PLANNING AMENDMENT

Application No: H18-0457-11/A1

From: G R Merchant Ltd [gr.merchant@btconnect.com]
Sent: 21 July 2011 16:27
To: Gedney, David
Subject: Re: H18-0457-11. Details of external materials, design of windows, storage/disposal of waste, etc, 112 Bridge Rd, Sutton Bridge - Mr G. Sangha
Attachments: 2132-10-05F Proposed A1.pdf

PROPOSED GROUND FLOOR PLAN
PROPOSED ELEVATIONS

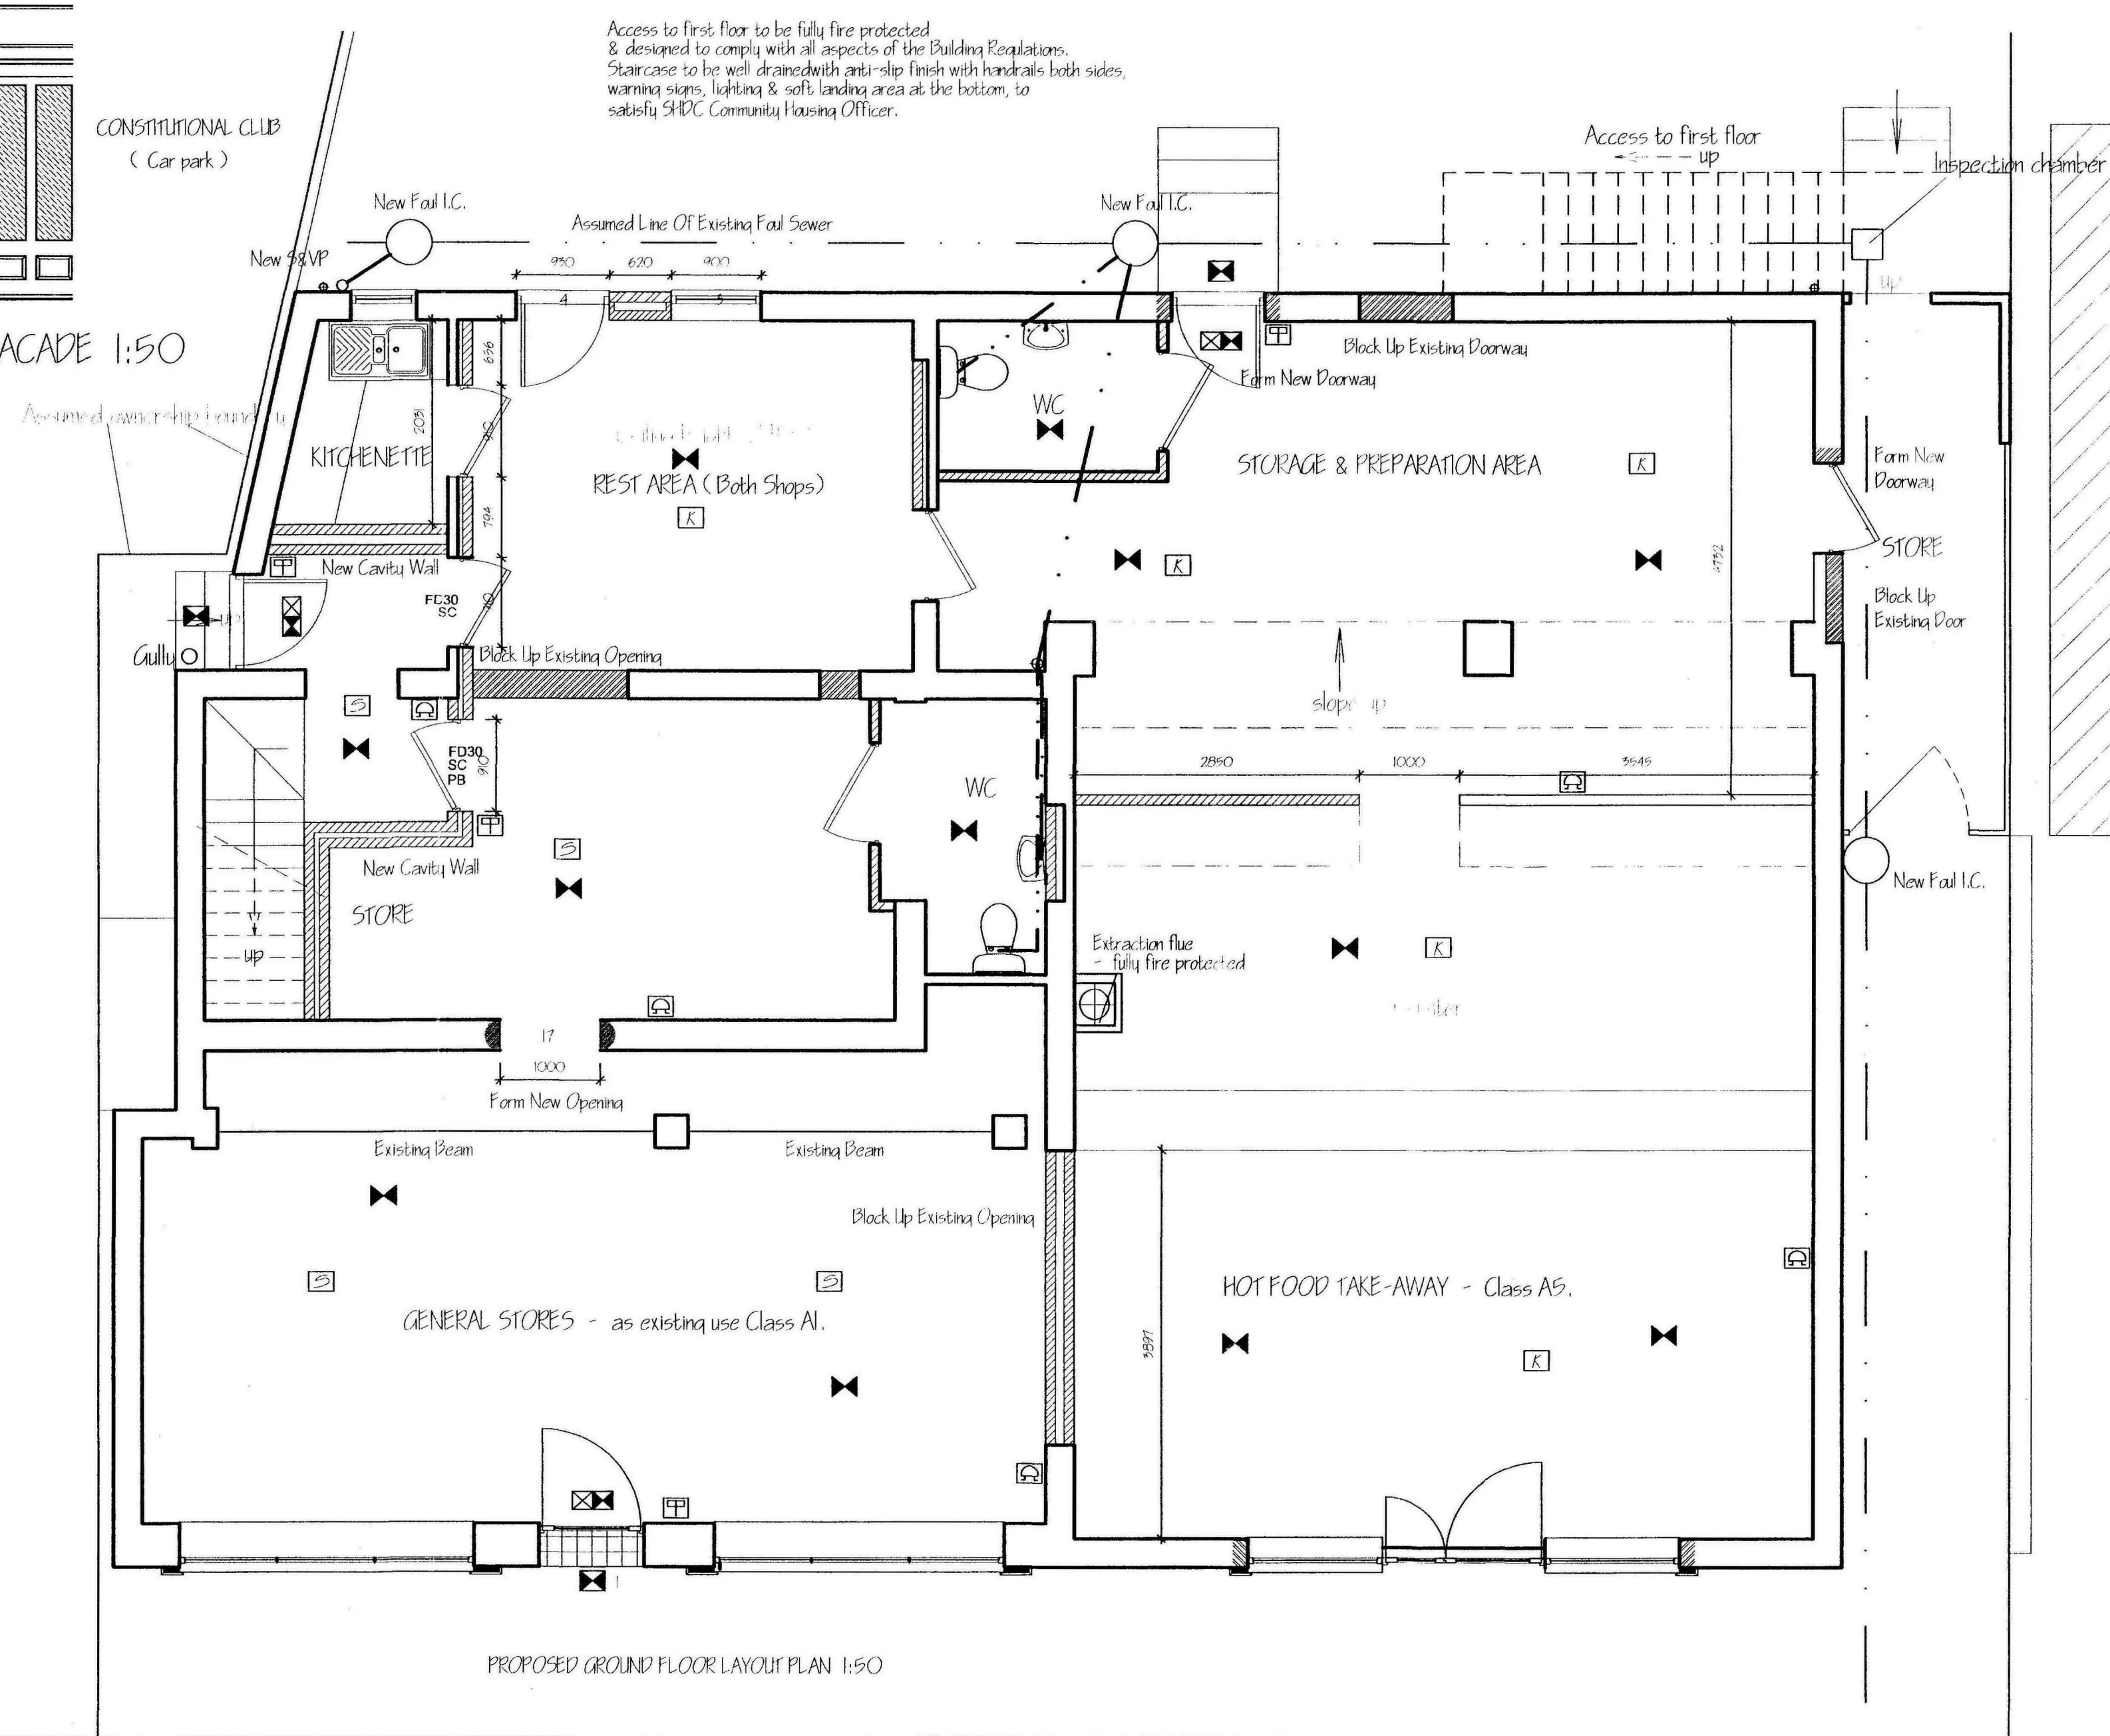
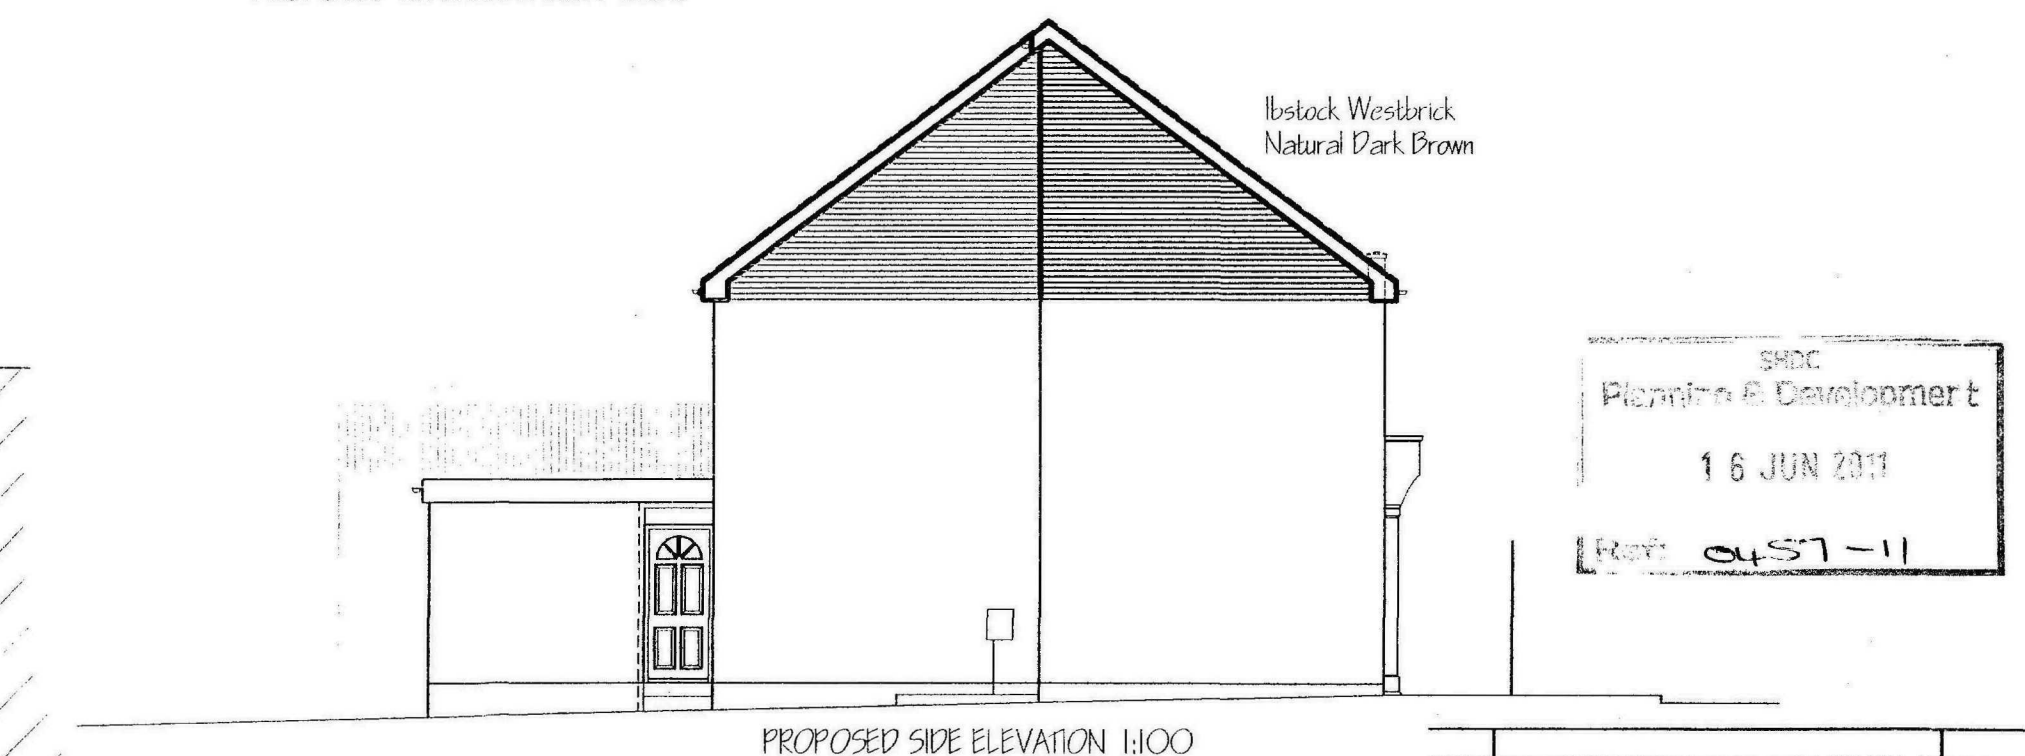
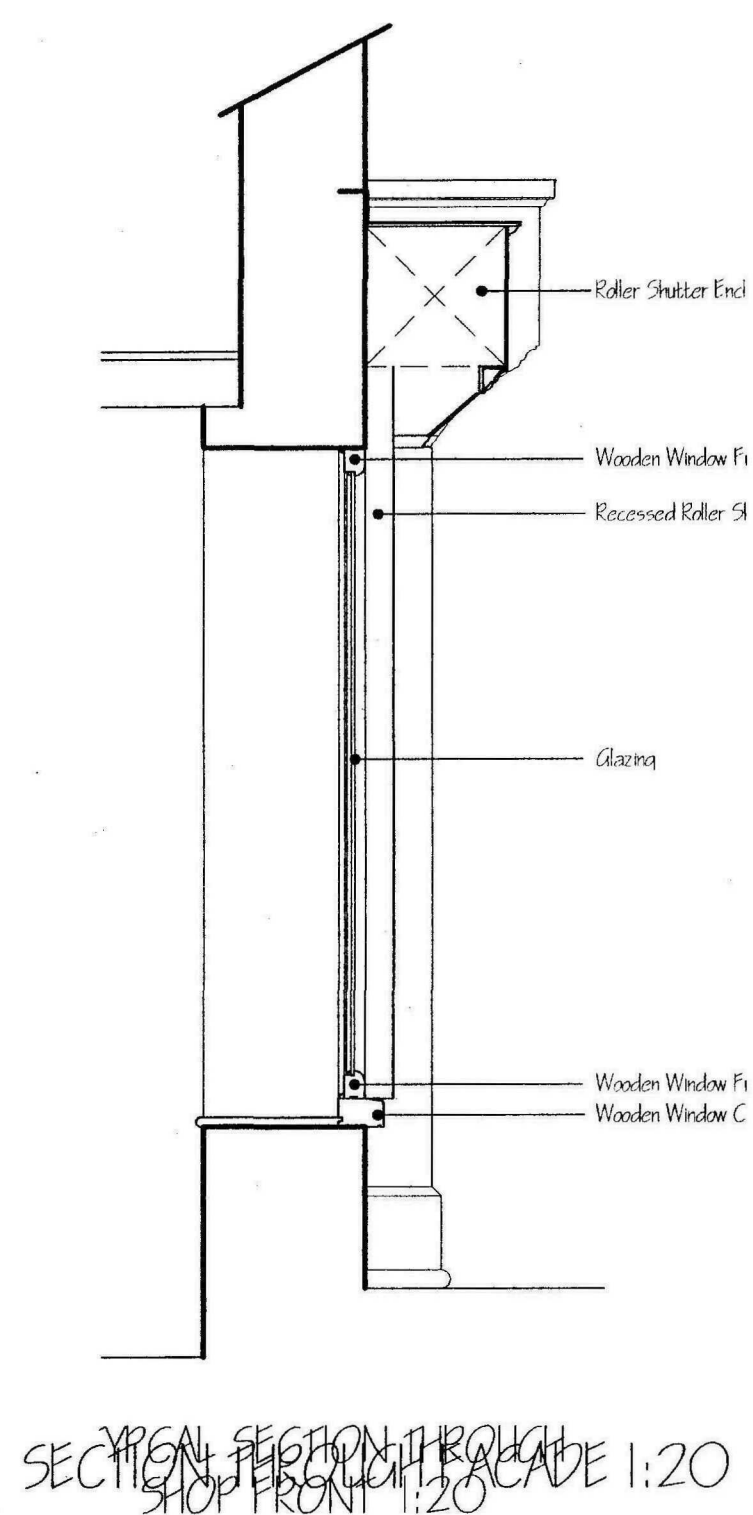
The submitted plans indicate that the new windows on the front elevation will be UPVC. However, they will need to be timber in accordance with Condition 5 of H18-0245-11. The design should be sliding sash given the site's important location within the proposed conservation area, in close proximity to listed buildings.

Please also provide details of the storage and disposal of waste food, etc from the takeaway.

- The brick change, as agreed on site.
- The UPVC windows removed on the front elevation and changed to Timber Sliding Sash.
